Application no: H13-0218-11

Description: Proposed ground floor extension to dwelling

Location: Old Chapel
Mill Marsh Road
Moulton Seas End
Spalding Lincs
PE12 6LR
PE12 6LR

ACKNOWLEDGEMENT OF AMENDMENT

DRAWING PROPOSED ELEVATIONS 3D VIEWS AND BLOCK PLAN
JOB REF DRAWING NO 3A DATE DRAWN JPW
SCALES 1/100 1/200 AND NO SCALES TO 3D VIEWS

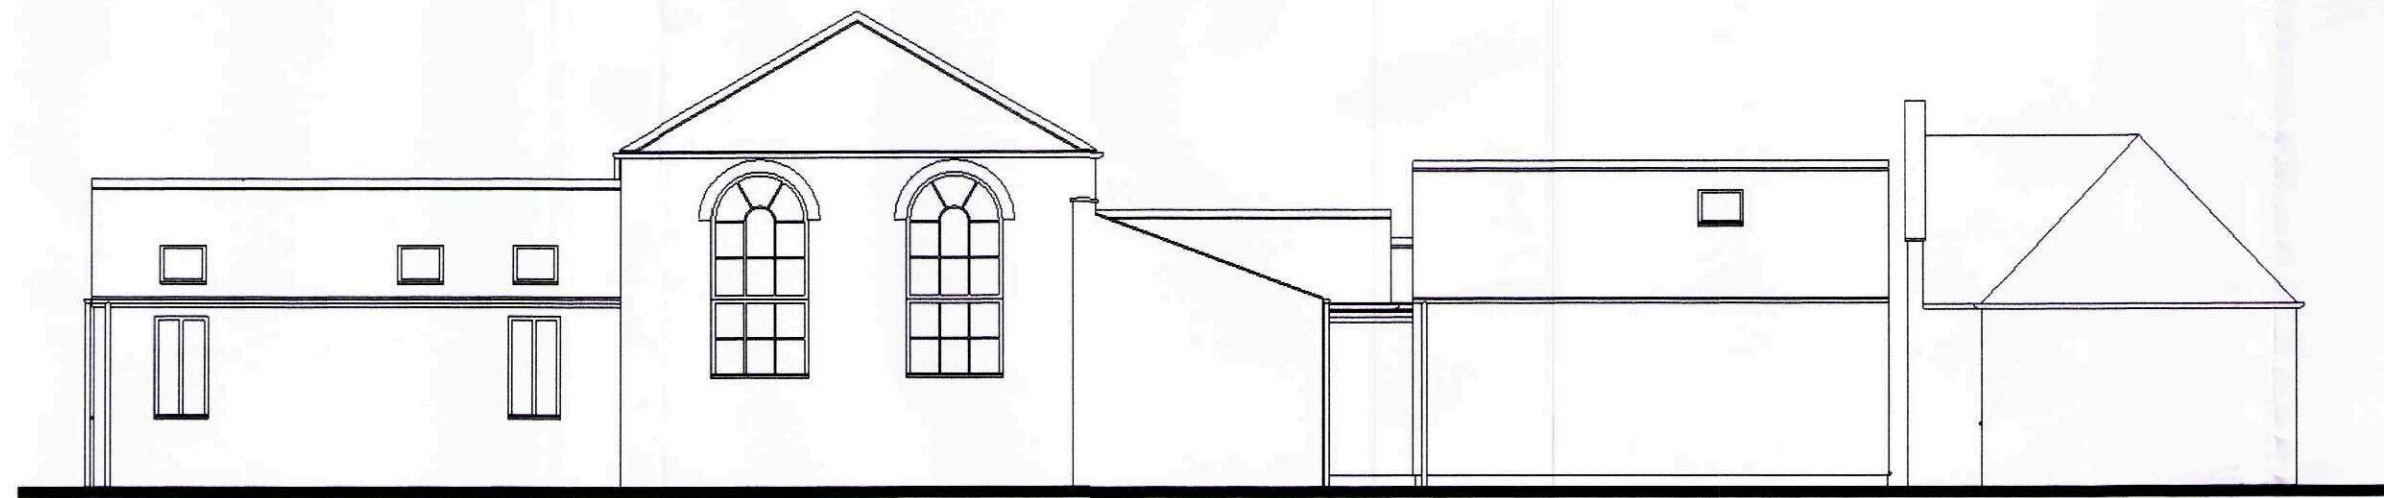
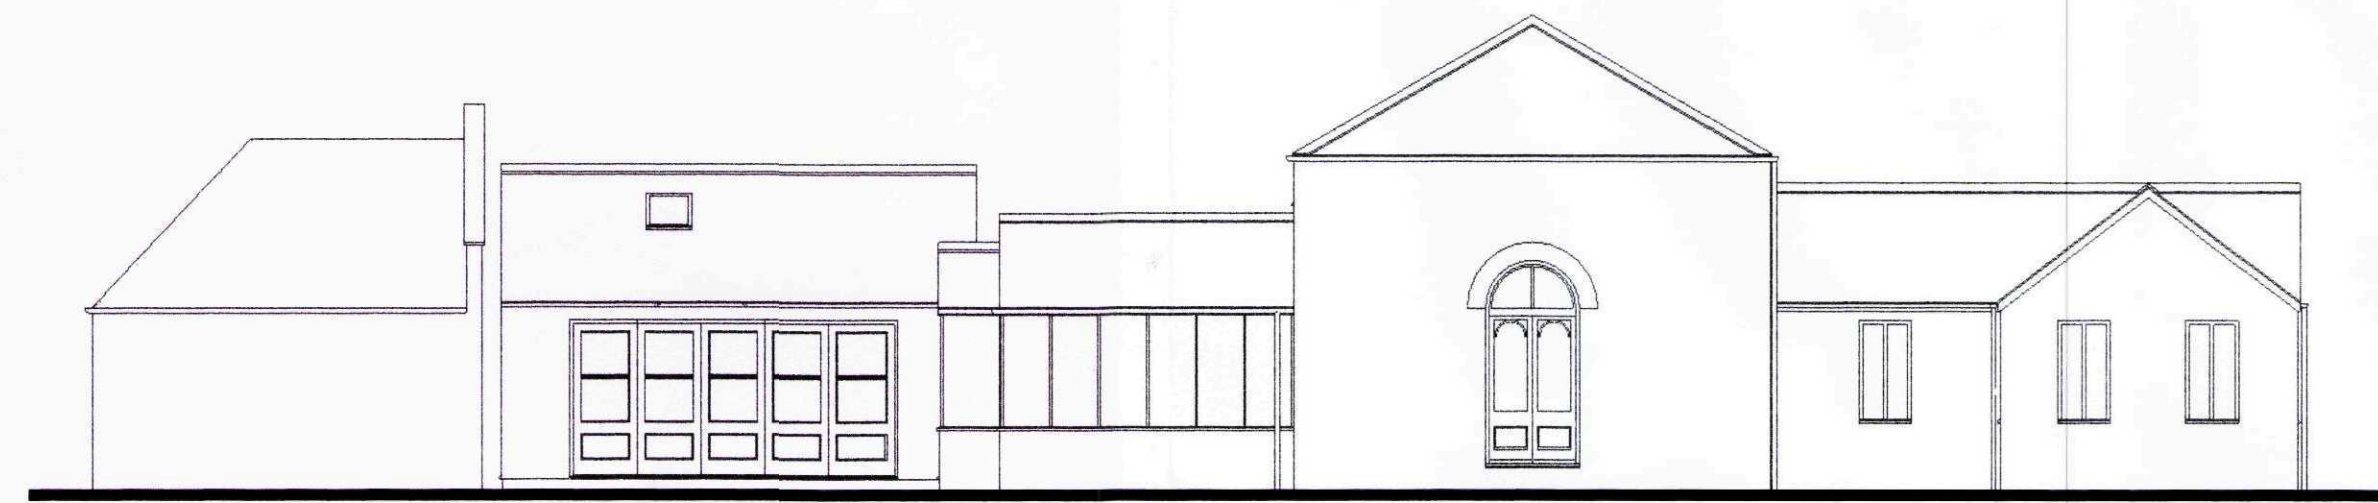
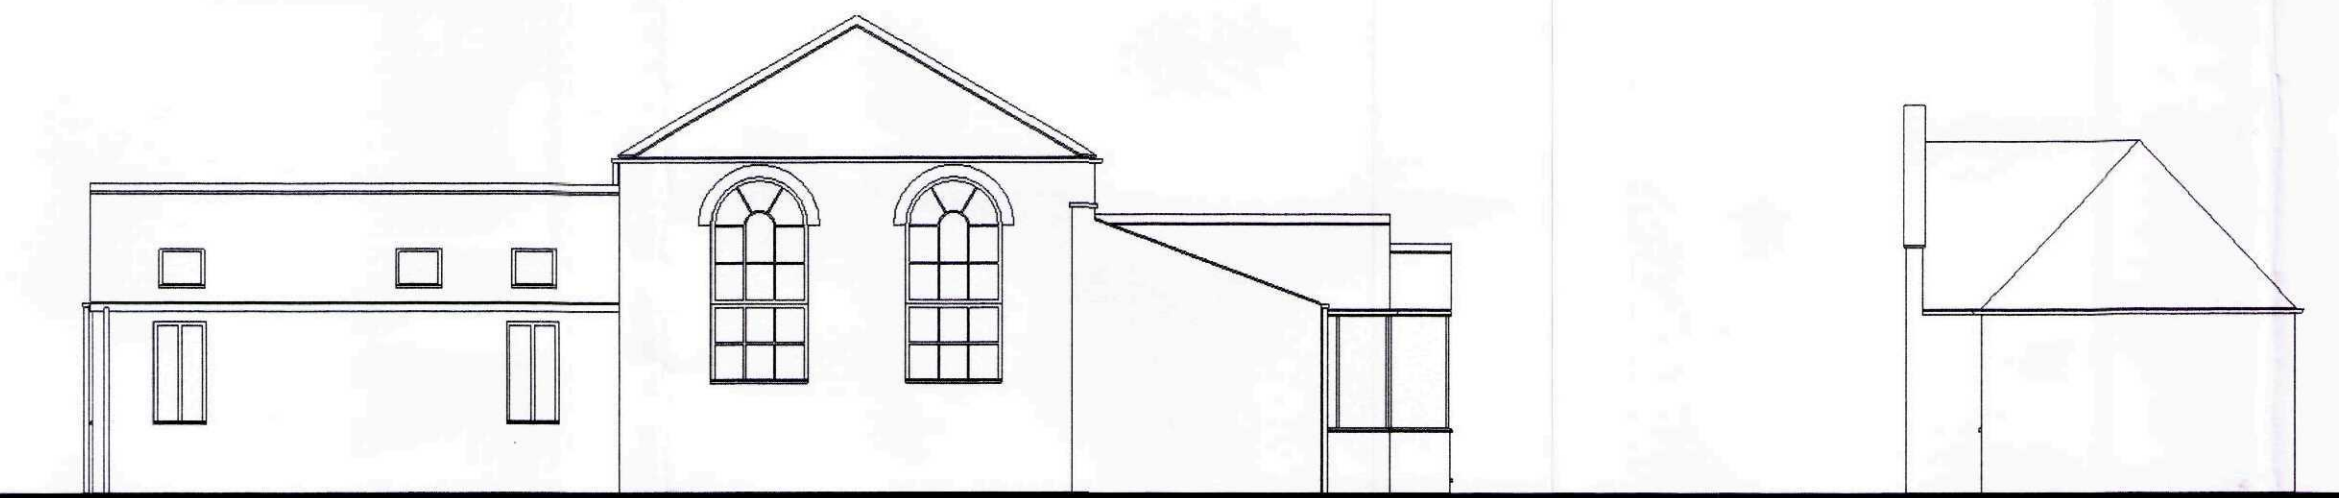
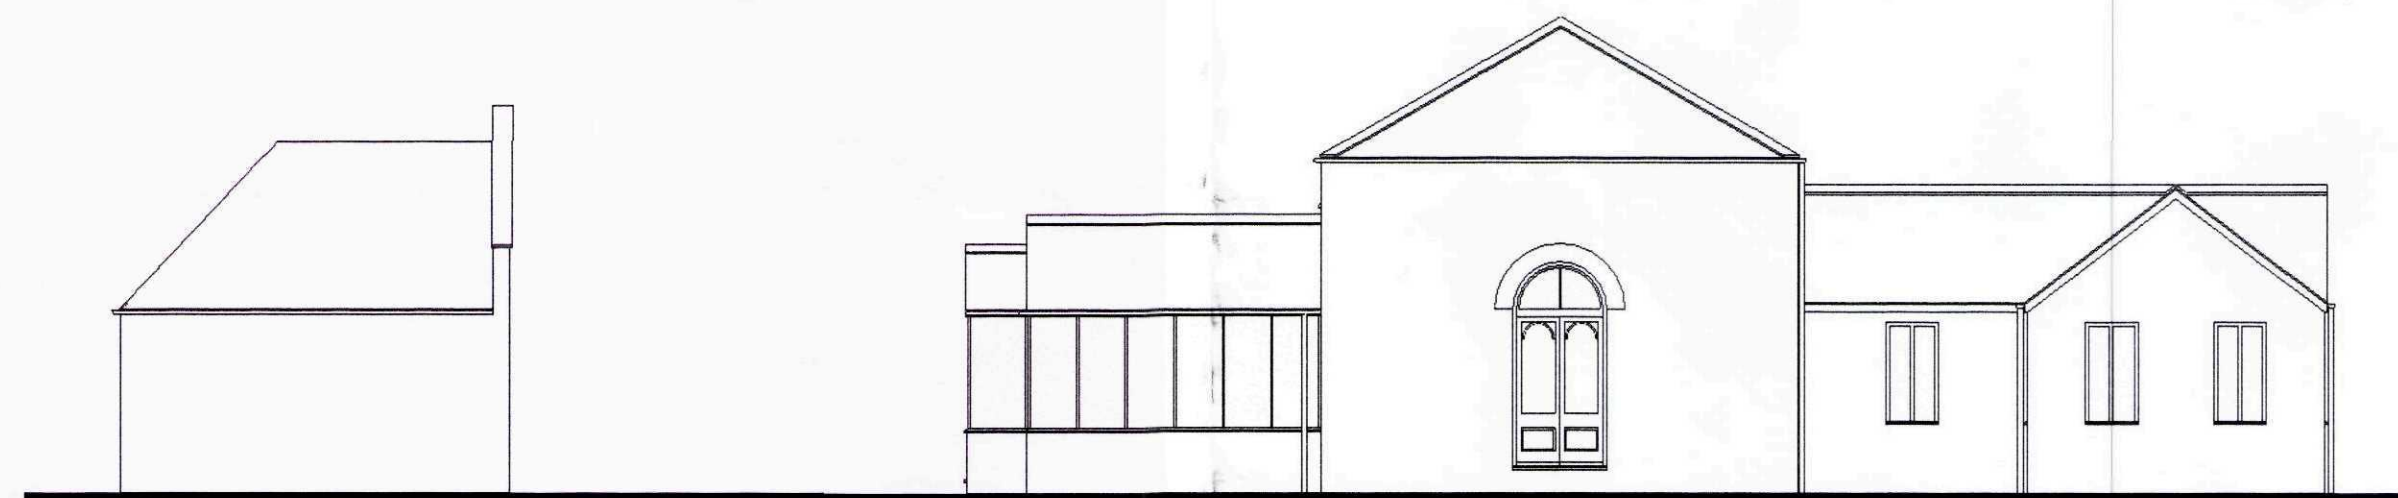
Amendment: Omitted box seat and flues (dwg. nos. 2210/11-01B,
2210/11-02A and 2210/11-03A)
